Please ask for: Ms Iqraa Malik
Email: iqraa.malik@terraquest.co.uk
Telephone: 0121 234 1390
Our Ref: BN/55/22/HH
Your Ref:
Date: 26th April 2022

Application for Planning Permission for Works or Extension to a Dwelling

Development: Erection of single storey rear extension following demolition of existing rear conservatory.
Location: 6 Collins Close Eastergate PO20 3JT

Drawing Title  
**Ground, First & Roof Plan  
as Existing**

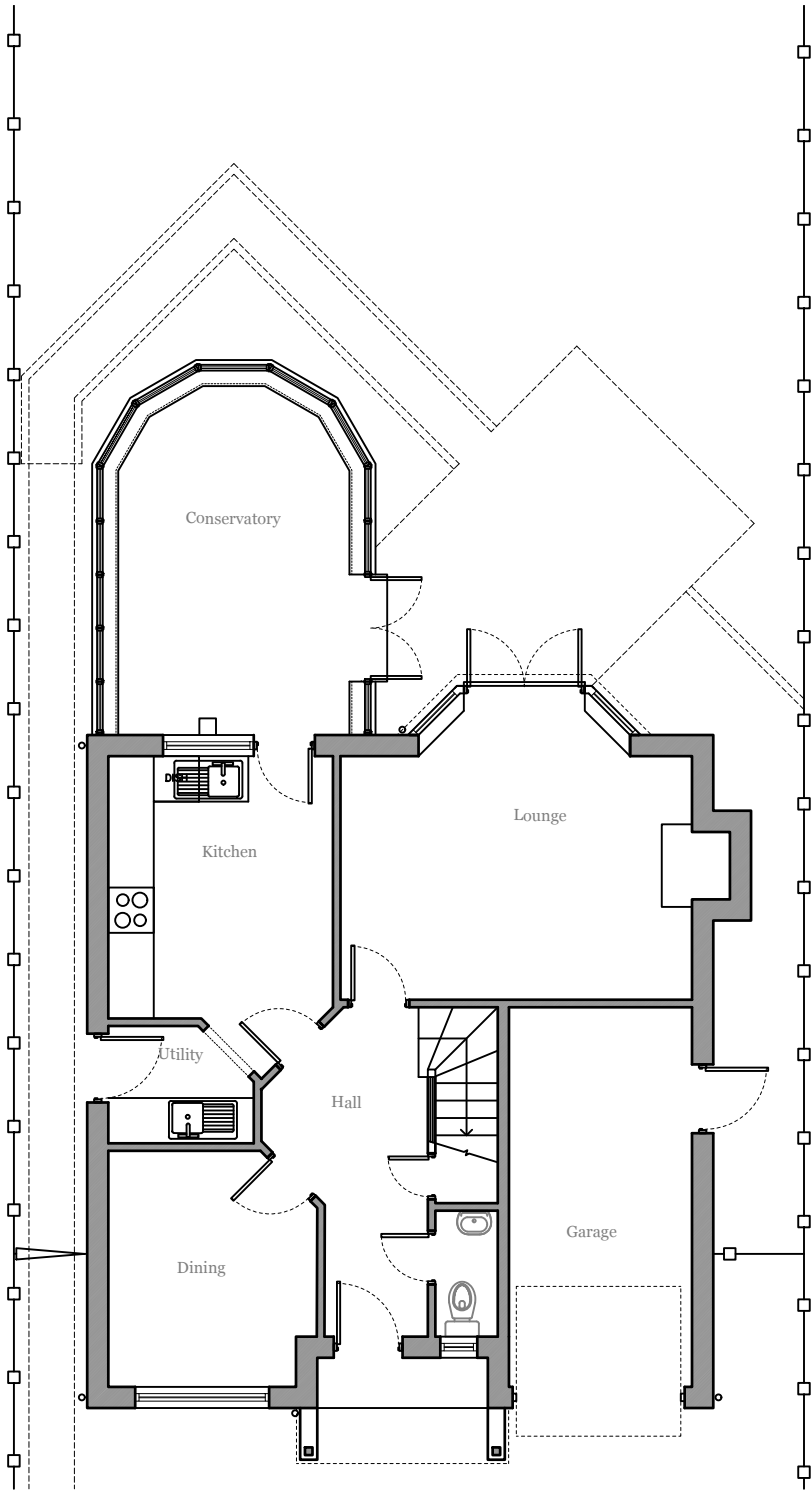
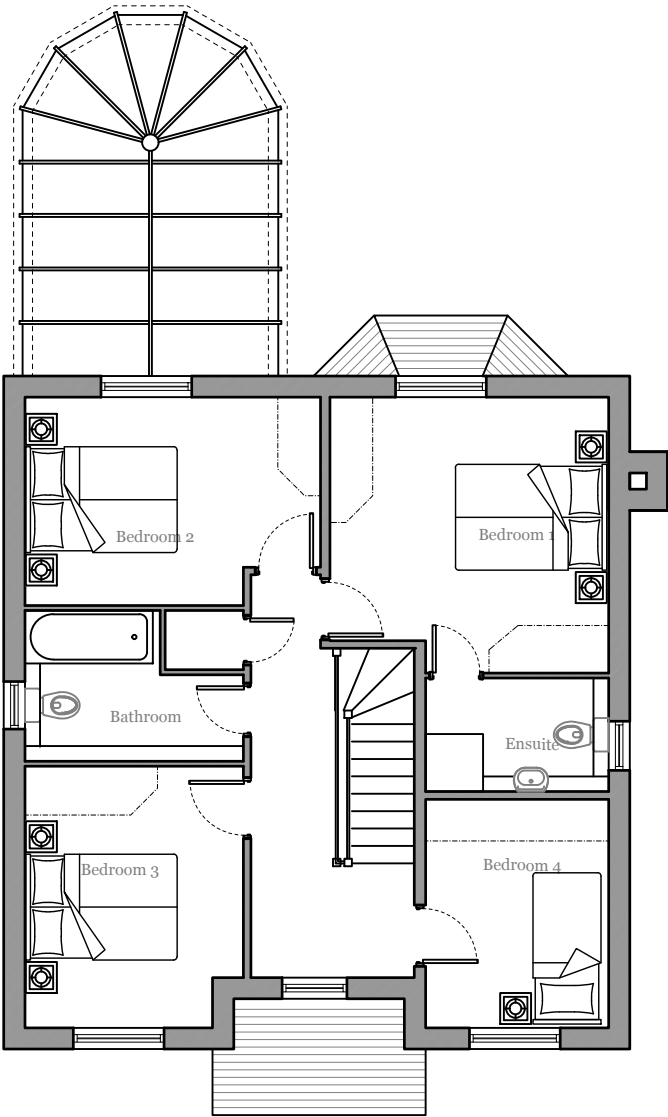
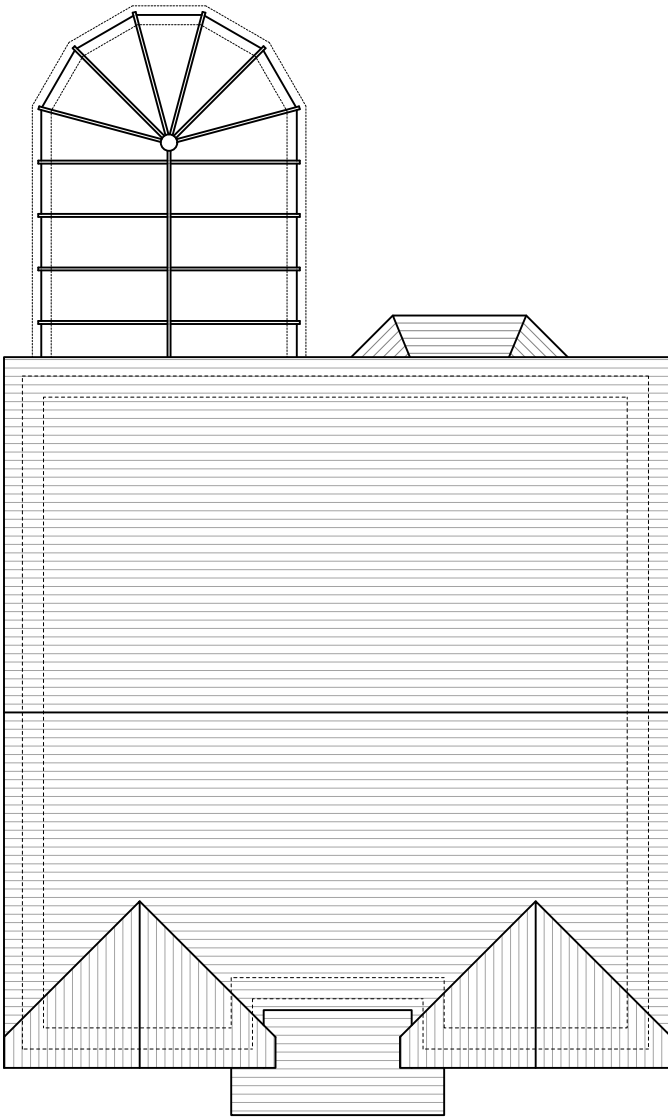
The windows displayed on the existing/proposed first floor plans are inconsistent with those on the existing/proposed front elevations. Please review and amend.

Drawing Title		
Block Plan as Proposed

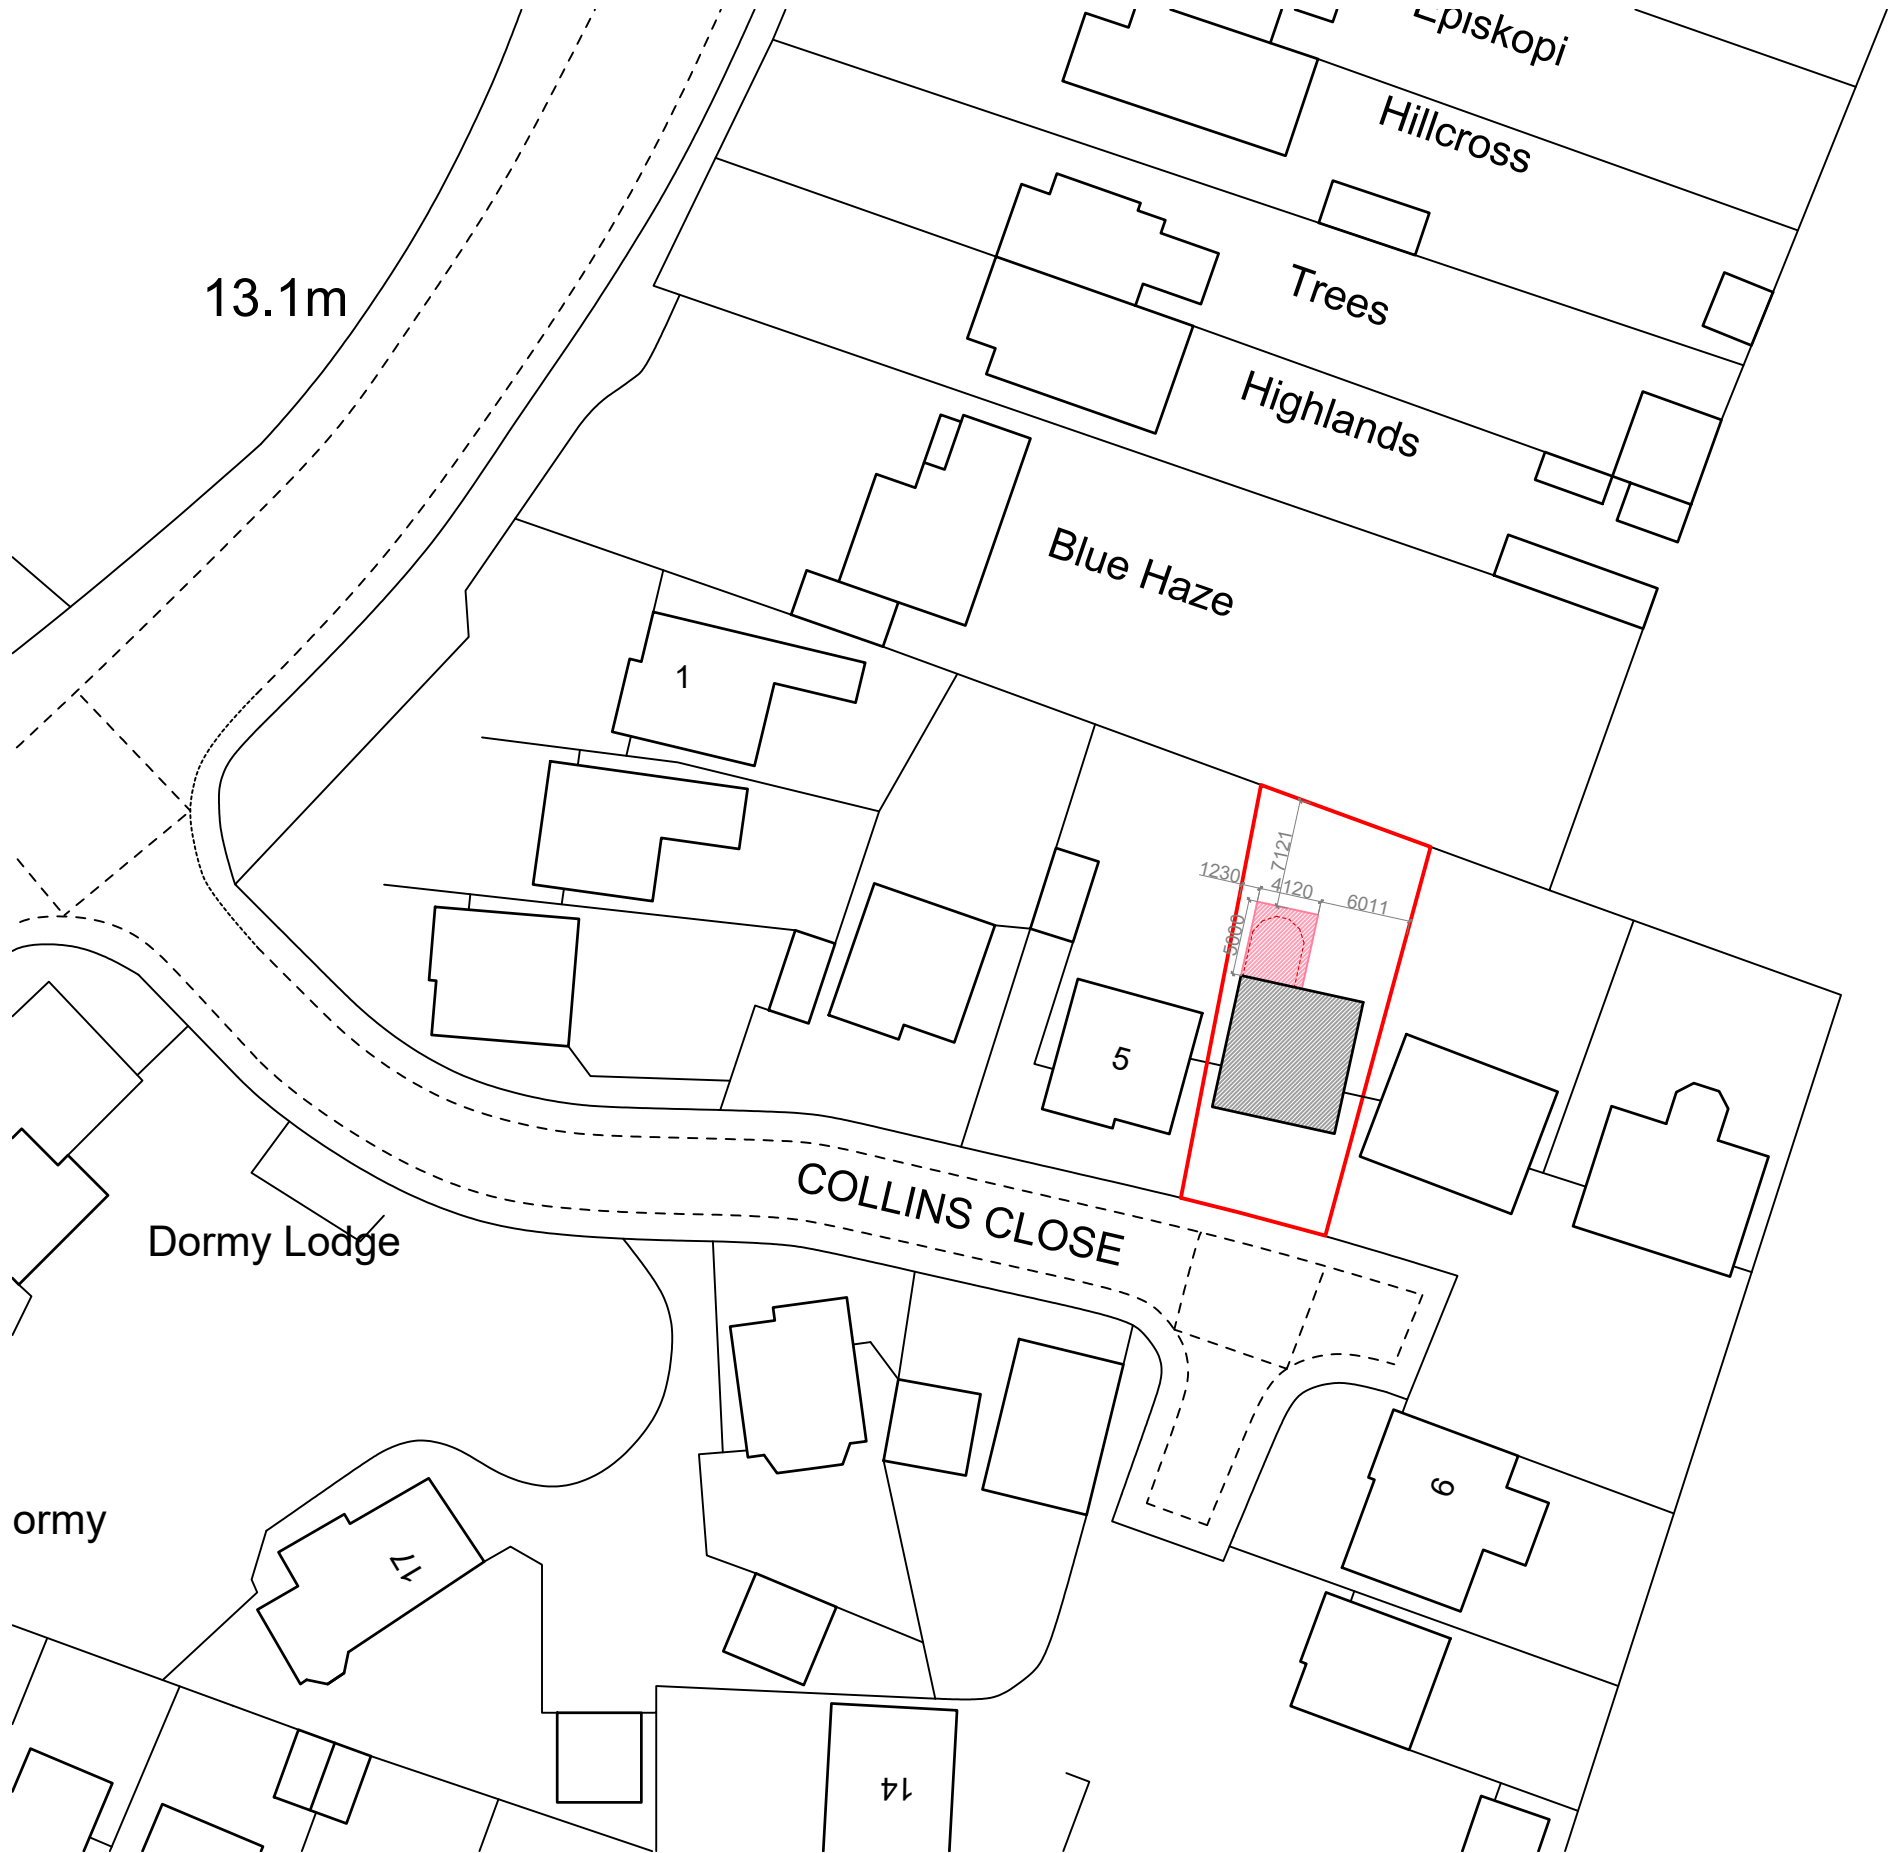
You are required to have dimensions from the proposed extension(s) to all site boundaries. Please amend.
